# CITY OF ALBUQUERQUE

April 18, 2022

**Re: Champion Xpress Car Wash  
9640 Universe Blvd NW  
Traffic Circulation Layout  
Engineer's Stamp 04-14-2022 (B10-D003J)**

C-2.2

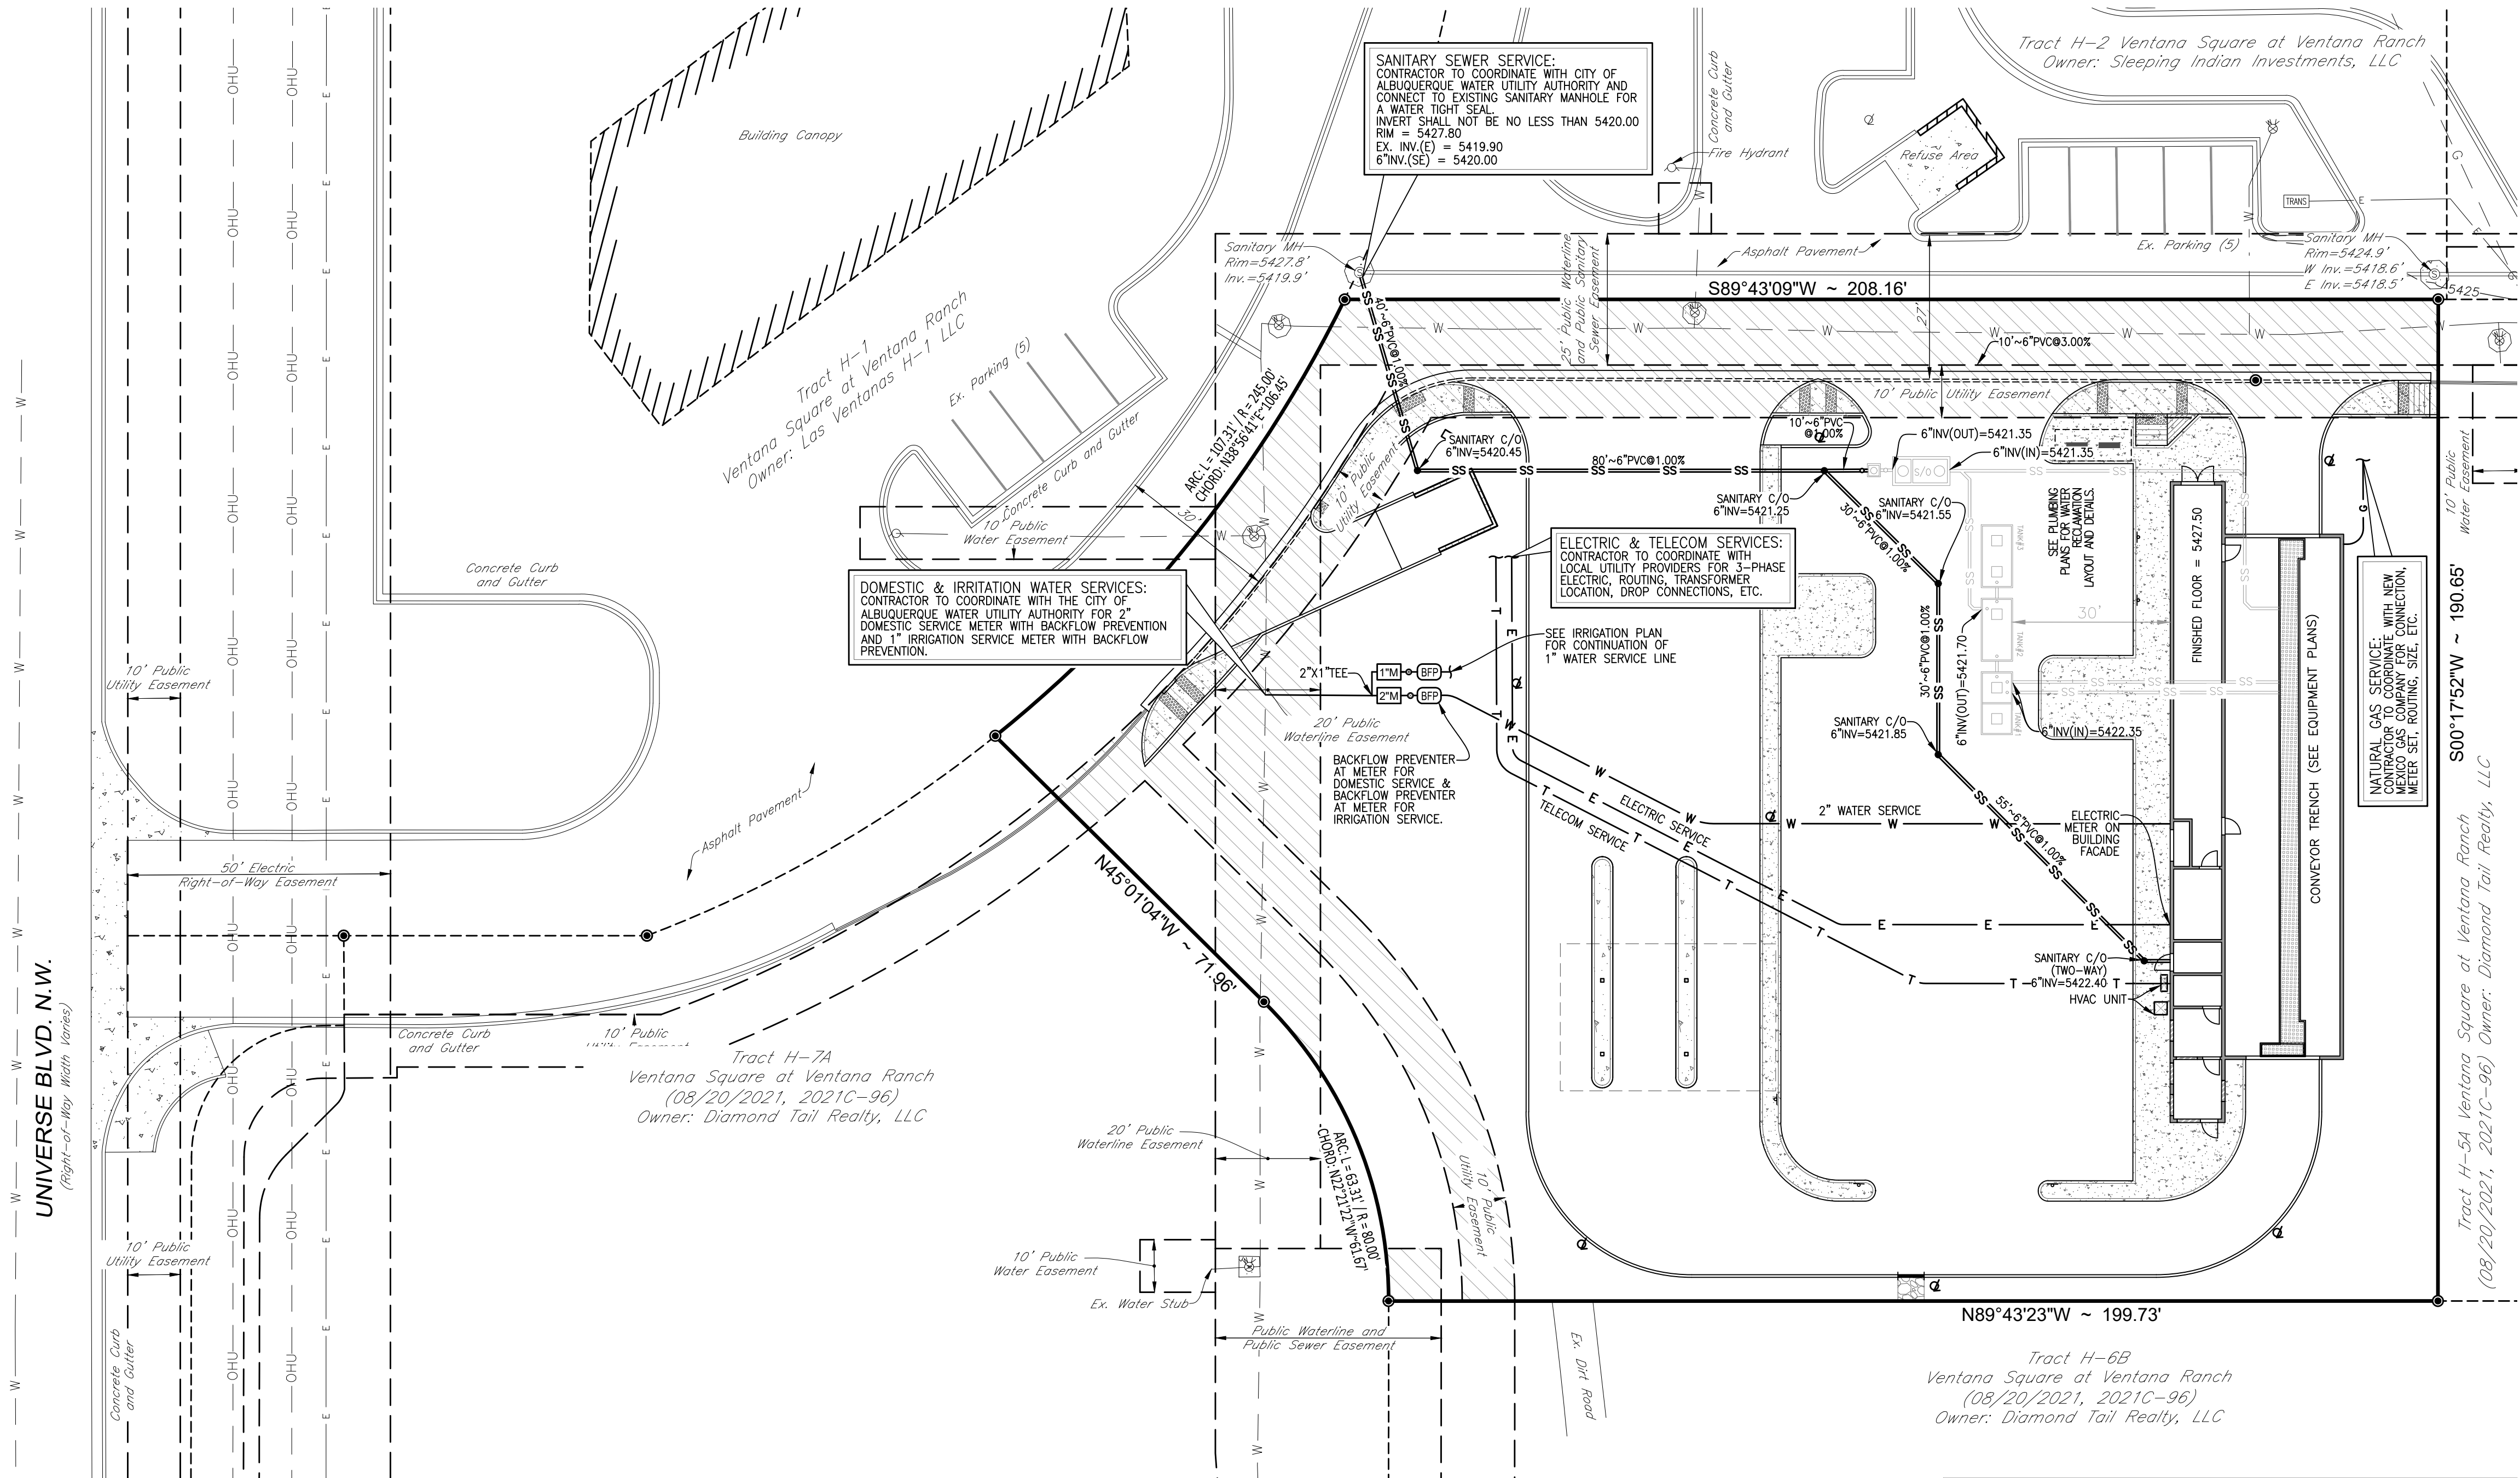
1. Sidewalk infrastructure on Tract H-7A will need to be in place prior to the issuance of a Final C.O. This is the condition set for sidewalk connection to Universe Blvd for this project.

**Coordinate/discuss with Zoning (Prior comment not addressed). You will need to coordinate/discuss with Zoning.**
3. **15 ft Private Access Easement (running West-East):**

- Proposed Curbing : Please provide a note defining the frontage curbing since line type has overlapped onto curbing.
  - A detail will be needed for back to back ramps and orthogonal ramp connection to ensure ADA accessibility is met.

- Are you proposing any type surface pavement design for the proposed 12.5 ft Access Easement? Or is it existing? Because there are no legends defining line type.

- Provide **Sheet 5.0** for review of truncated domes ( as stated on your response letter)
4. The ADA access aisles shall have the words **"NO PARKING"** in capital letters, each of which shall be at least one foot high and at least two inches wide, placed at the rear of the parking space so as to be close to where an adjacent vehicle's rear tire would be placed. (66-1-4.1.B NMSA 1978). **Provide detail for pavement marking text " NO PARKING".(prior comment not addressed)**

5. Per DPM, a 6 ft. wide ADA accessible pedestrian pathway is required from the ADA parking stall access aisles to the building entrances. Please clearly show this pathway and provide details. **You will need a ramp to connect VAN access aisle to pathway to restroom entrance. There is a thick line type covering the access onto the 6ft ADA pathway to restroom so not able to define proper ADA accessible route.**
